August 8, 2014

**Subject: Congress Street Convenience Store –Portland, Maine
Comment Response # 1
Response to City of Portland Comments of Jean Fraser Dated August 1, 2014**

We have received and reviewed the email review comments dated August 1, 2014 regarding the Amended Site Plan for the 2282 Congress Street Convenience Store project. We have completed plan revisions related to these comments as well as revisions based on the client's value engineering requests. For ease of reference, we have repeated the comments (*italics*) followed by our response.

Drawing file: Aug8_misnum sub / C-9.1A.pdf

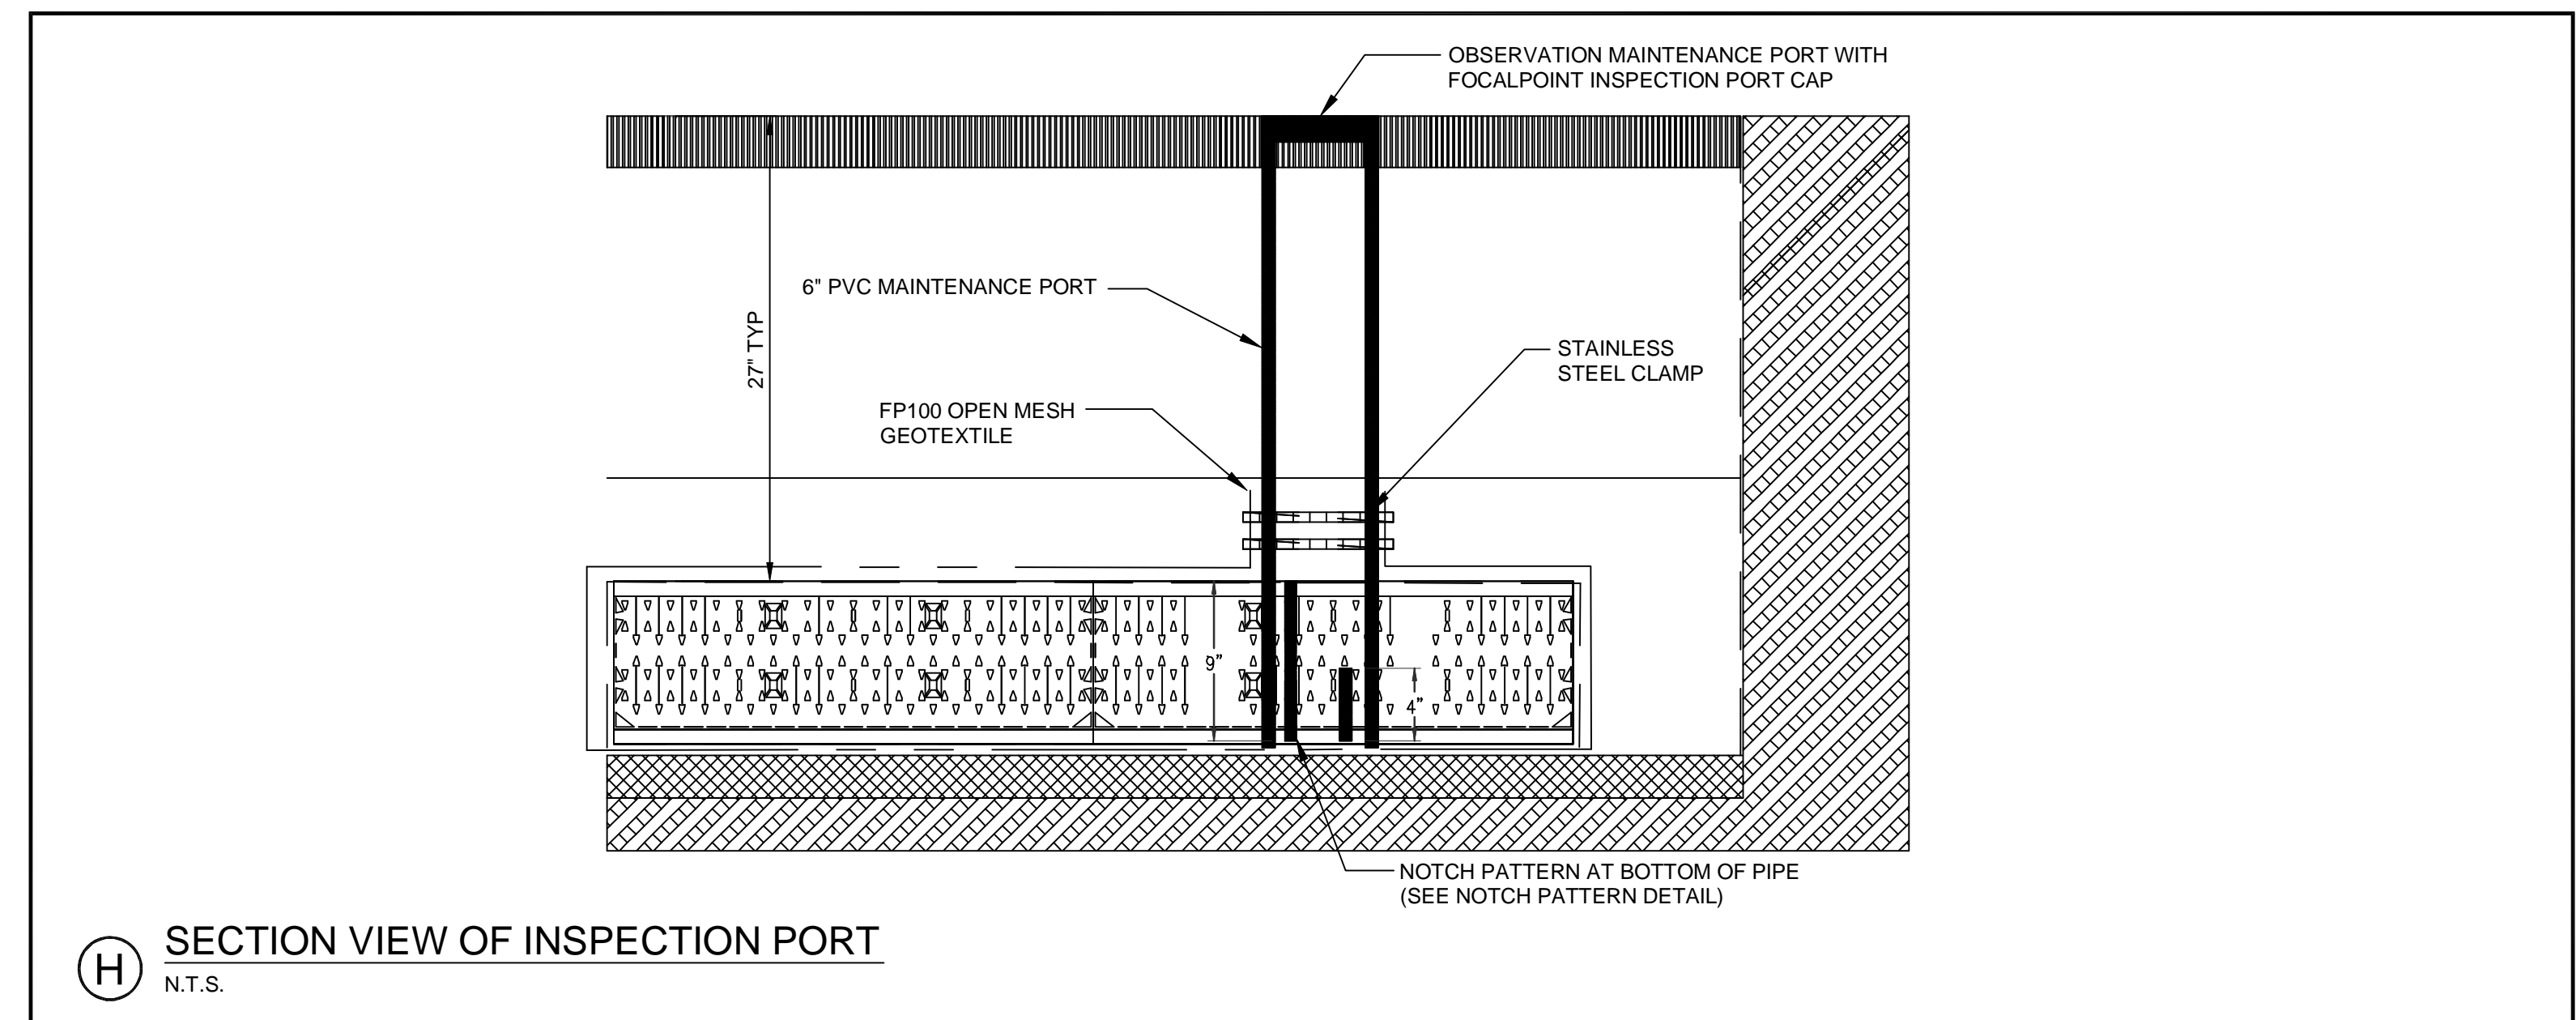
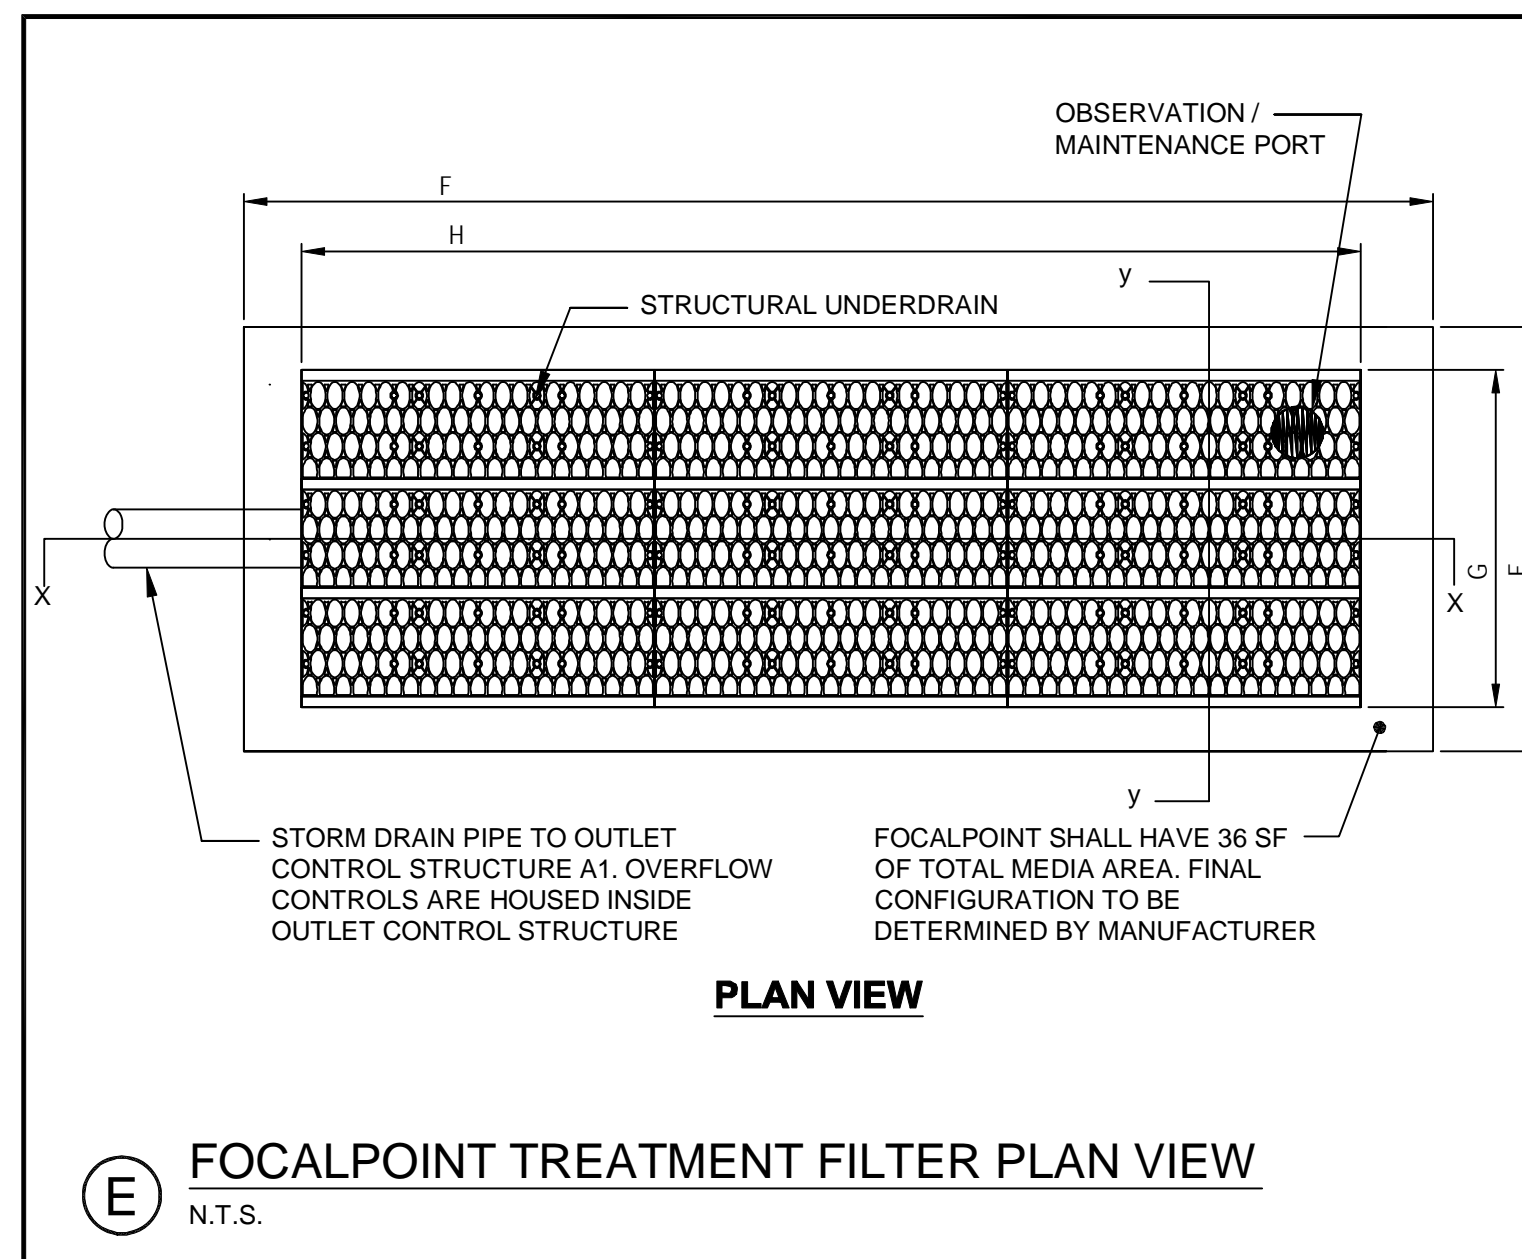
The Focal Point™ system requires a maximum water ponding depth of 0.5’ in the stormwater detention basin. This requires water release controls inside of the outlet control structure A-1 to be lowered from 89.62’ to 88.92’. The change in outlet control elevations required a re-design of the outlet control structure. In order to control the 2-year peak flow a 3” orifice was computed to control the flow at the water quality elevation of 88.92’. This resulted in the following Detention Pond “0” impacts:
